Please see below a list of adjustments we have made following the previous planning application submitted. We have addressed the concerns of the neighbouring properties as well as the planning officer. Below we have outlined the adjustments we have made to the overall proposal to address these points which we consider to be much more favourable to the planning office.

Adjustments we have made to address the points of the planning officer and comments of the neighbours

05 PROPOSED GROUND FLOOR PLAN
SCALE: 1:100

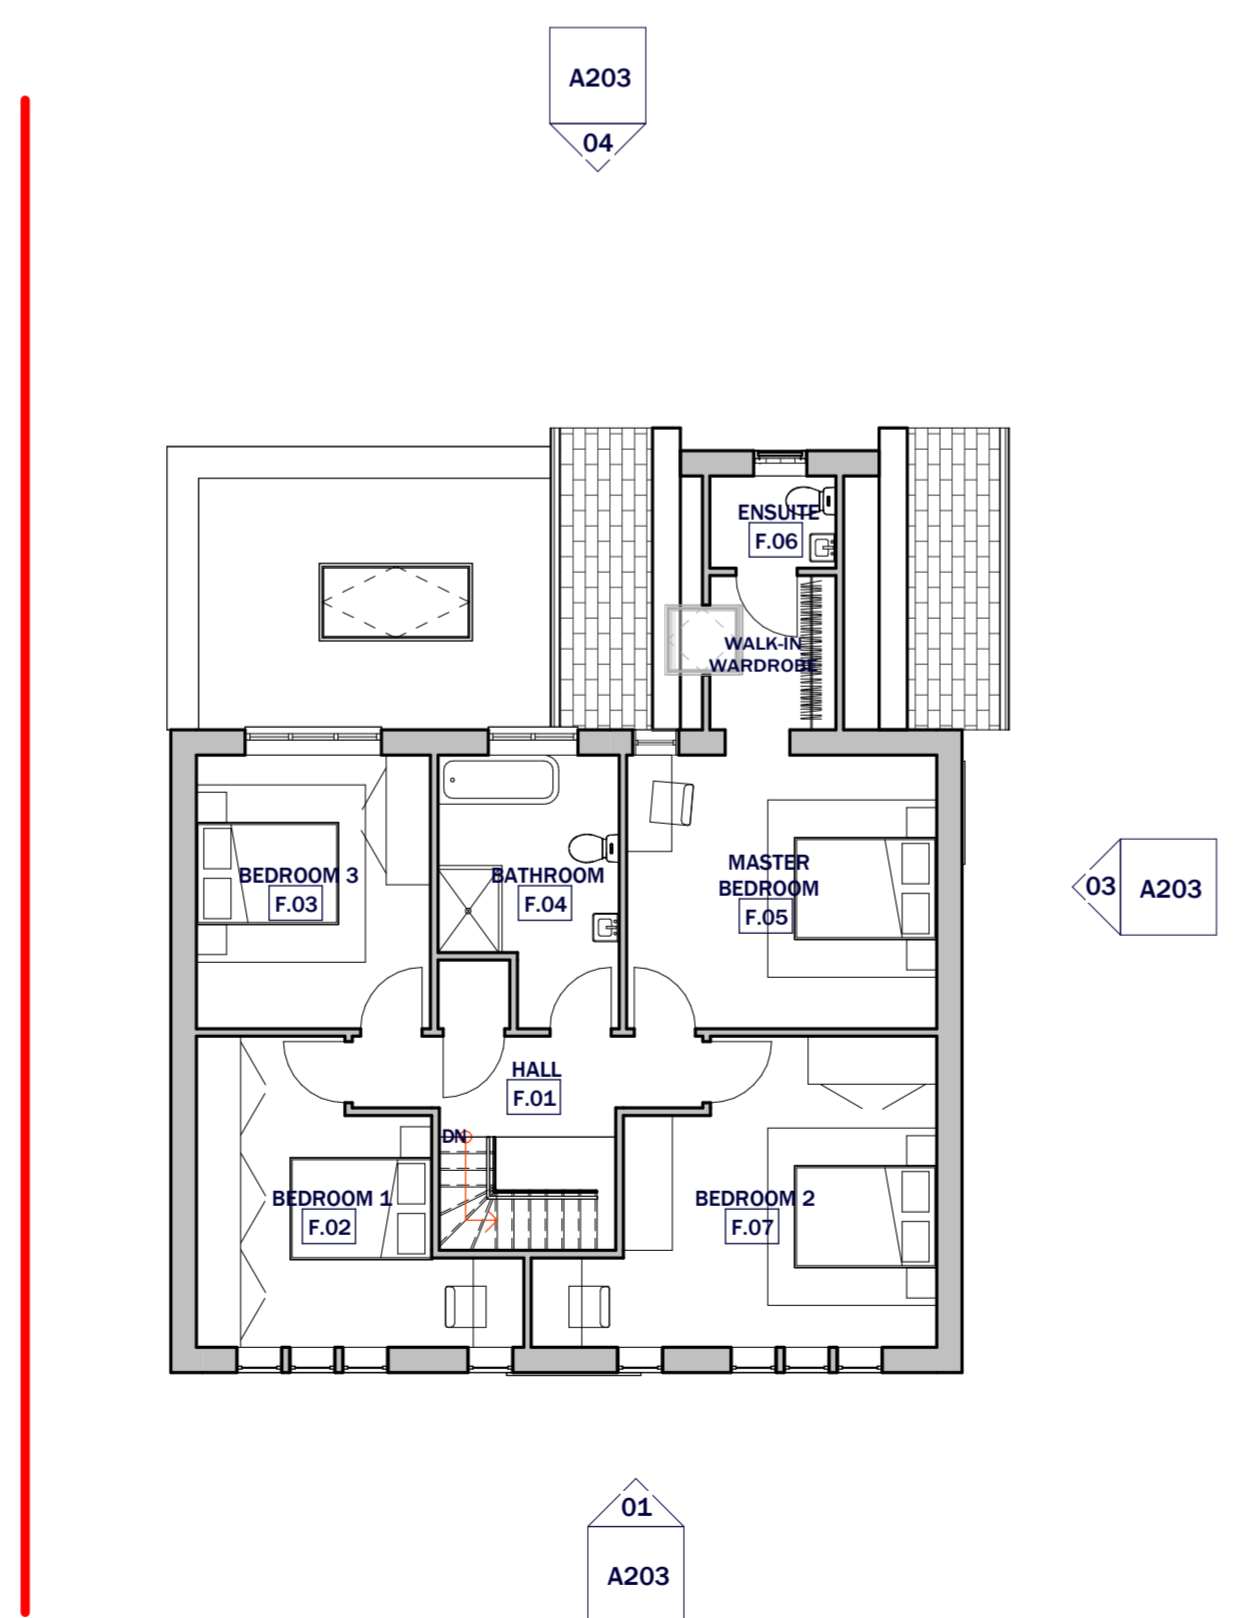
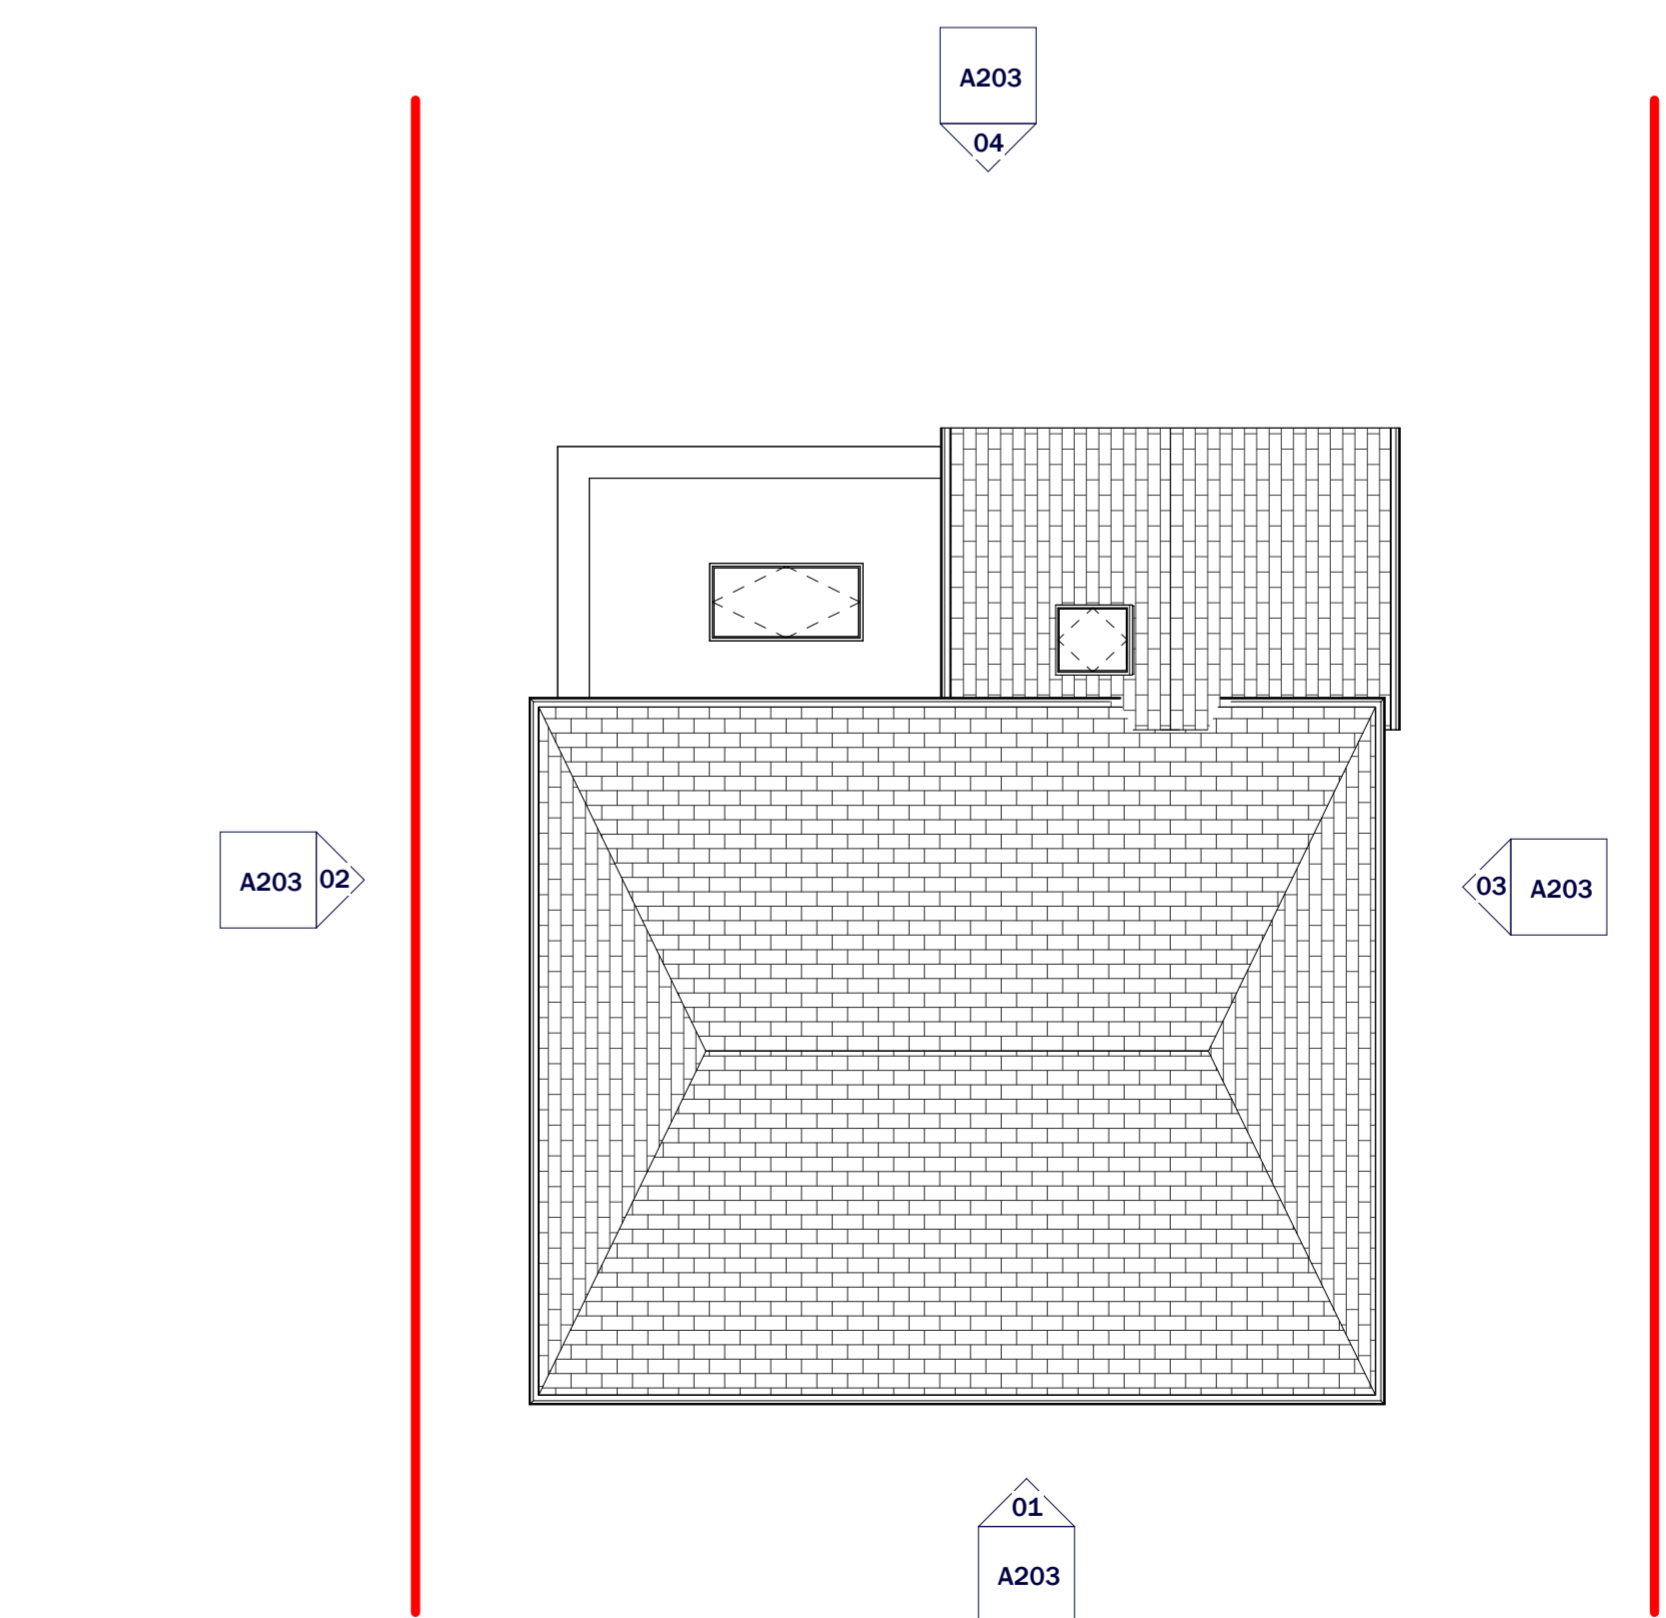
1. Reduce the ridge height so that it matches the existing ridge height (Achieved by a combination of the below adjustments)
2. Reduce the eaves height from the previous proposal
3. Removed the side master bedroom window - a point by your neighbour - We have added a smaller window facing the rear garden
4. Reduce the pitch angle of the roof to 20 degrees
5. Reduced the size/height of the first-floor windows to 1100mm
6. Reduced the level of the first-floor window cill heights to 700mm - Still allowing for a generous size window to push light into the bedrooms
